DECISION DELEGATED TO HEAD OF PLANNING

Application No: H17-0028-26 **Applicant:** Mr J Heppenstall

Proposal: Demolition of existing dwelling and construction of new replacement dwelling and double garage

Location: 20 The Reservoir Surfleet Spalding

Drawing No - 2a

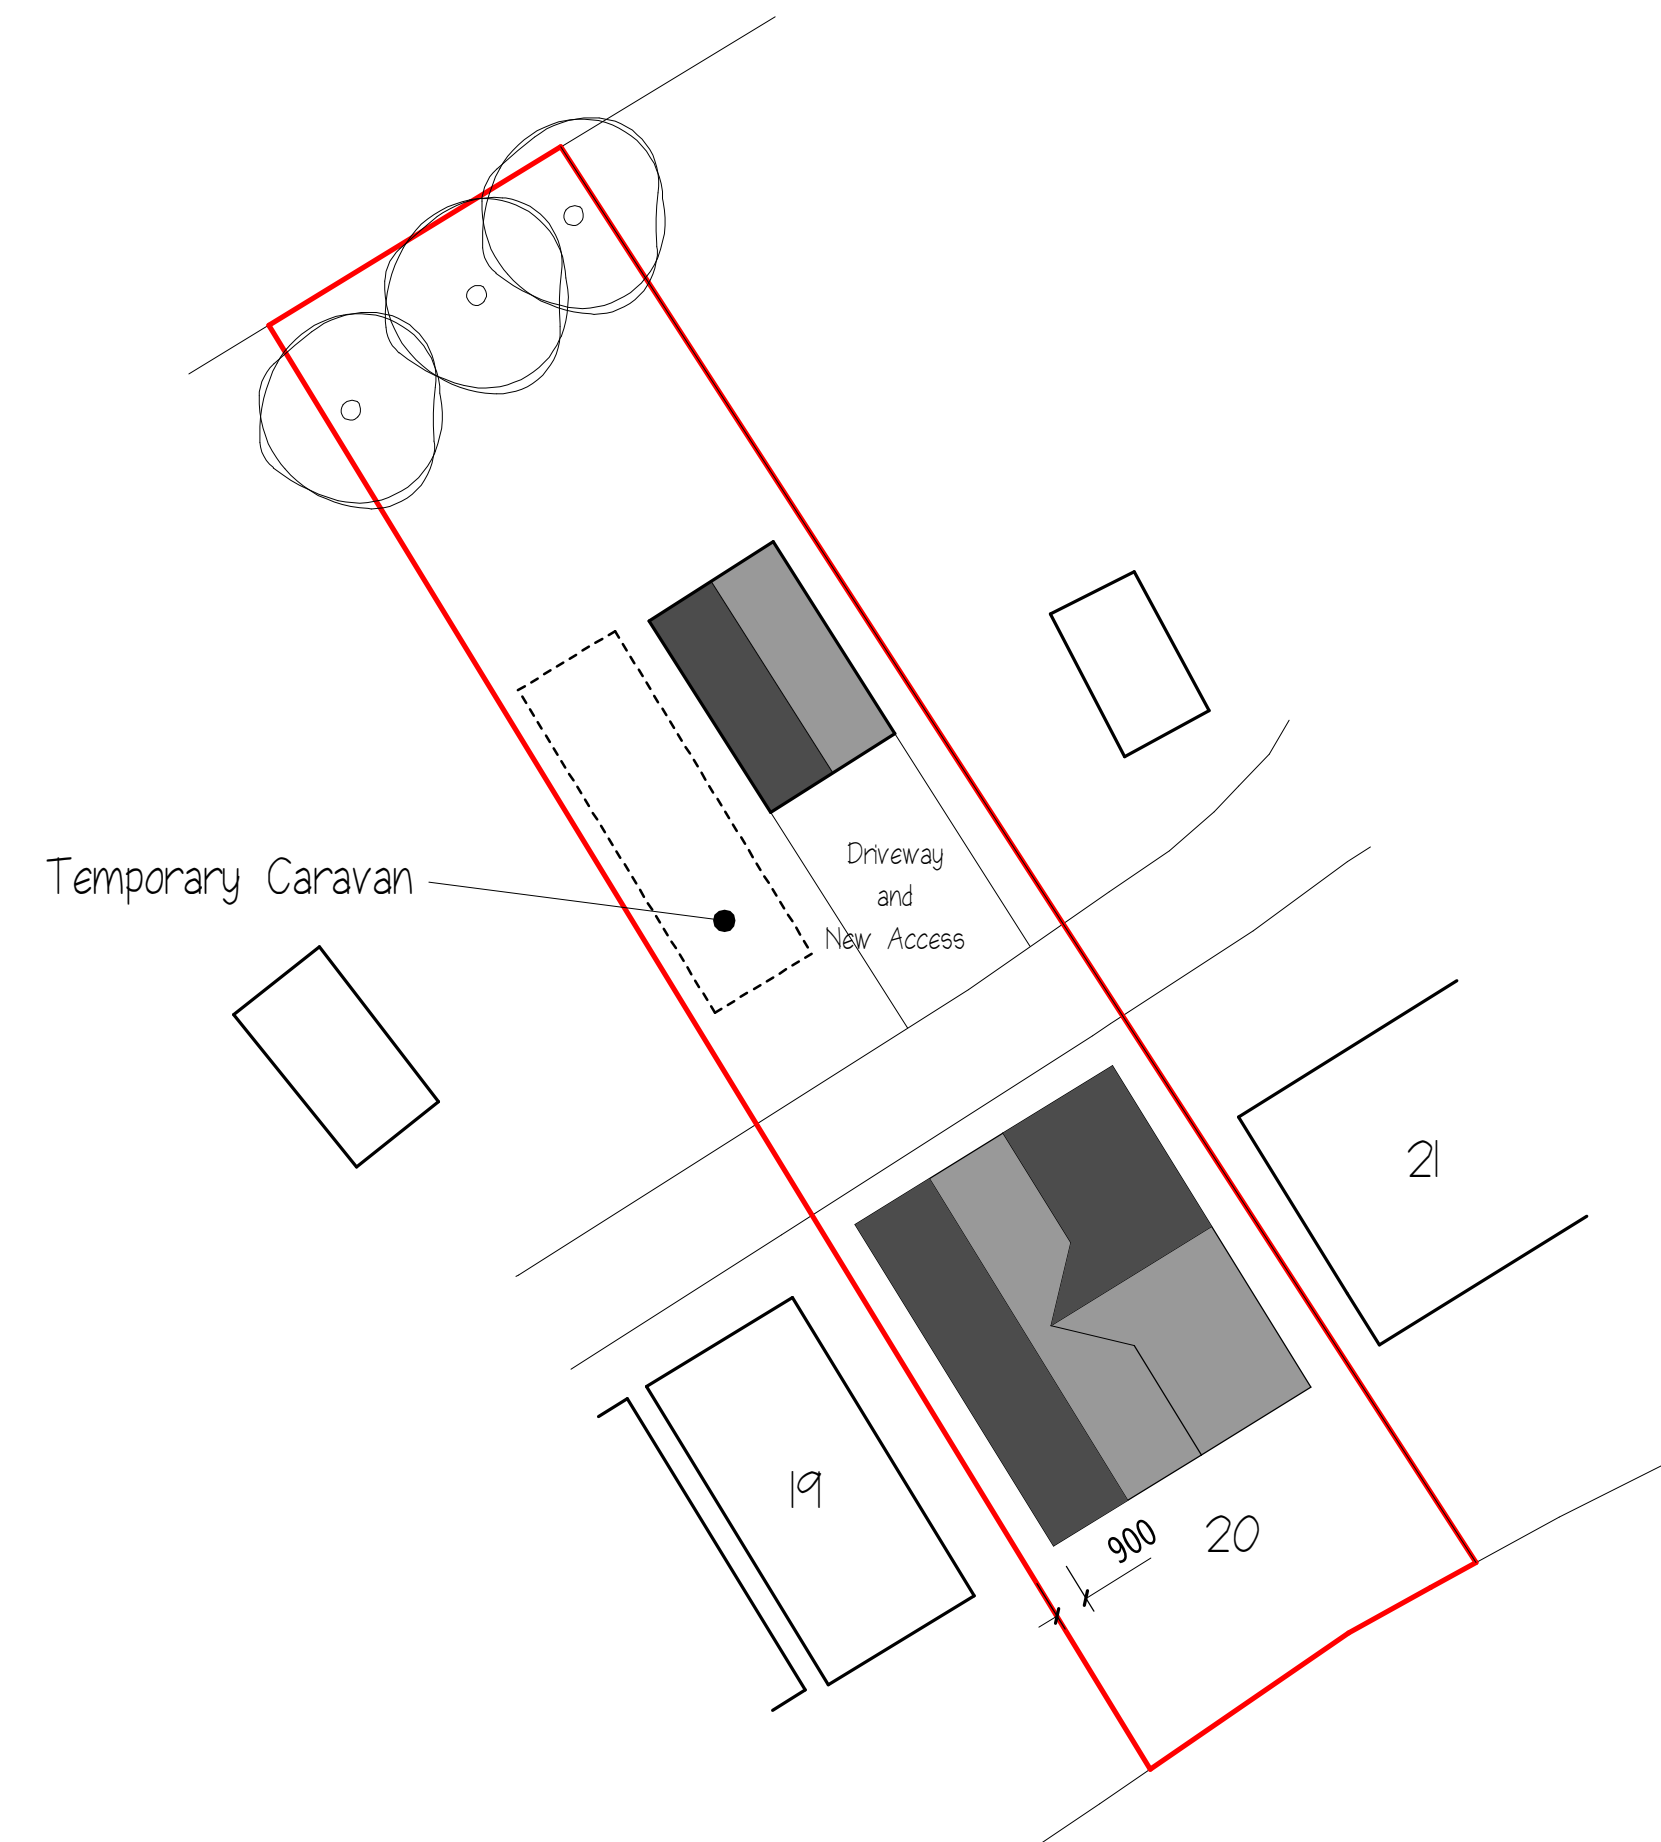
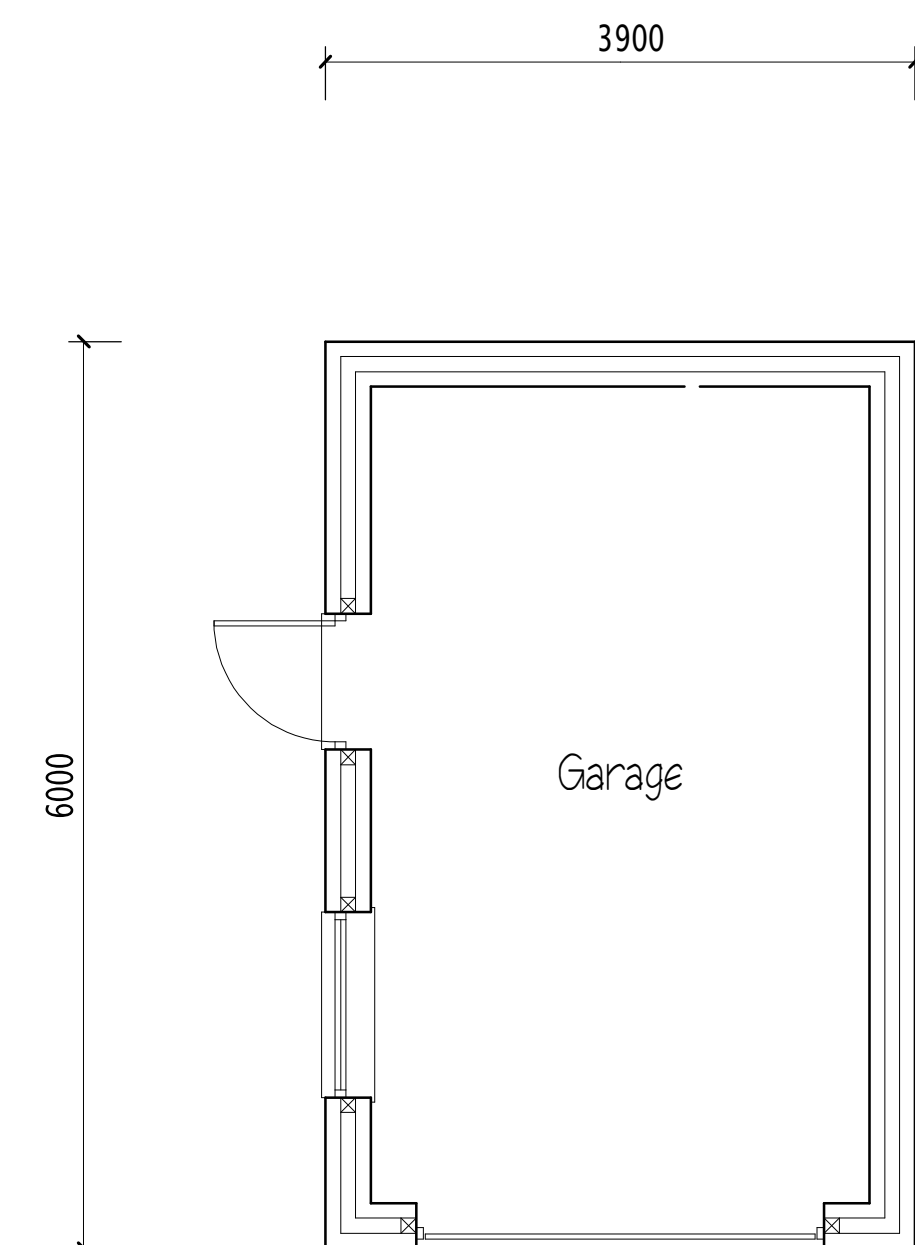
Initially, a detached garage building was proposed in the northern portion of the site to replace two existing outbuildings. The proposed outbuilding would have featured two storeys and it was

considered that the overall height and scale of the outbuilding would have been relatively large. This was discussed with the applicant's agent and revised plans have been provided reducing the scale of the outbuilding. The building is now proposed to be a single storey building. The scale of the building has also been reduced for flood risk mitigation purposes as the Environment Agency advised that the overall built footprint within the site should not exceed the existing built footprint.

The outbuilding is proposed to measure 6m in length and 3.9m in width. The building is proposed to feature a gable end roof form that measures 4m in height up to its ridgeline and 2.2m up to its eaves. The revised proposal for the outbuilding is considered to be acceptable as the outbuilding is considered to feature a suitable design in terms of its scale, siting and overall appearance.
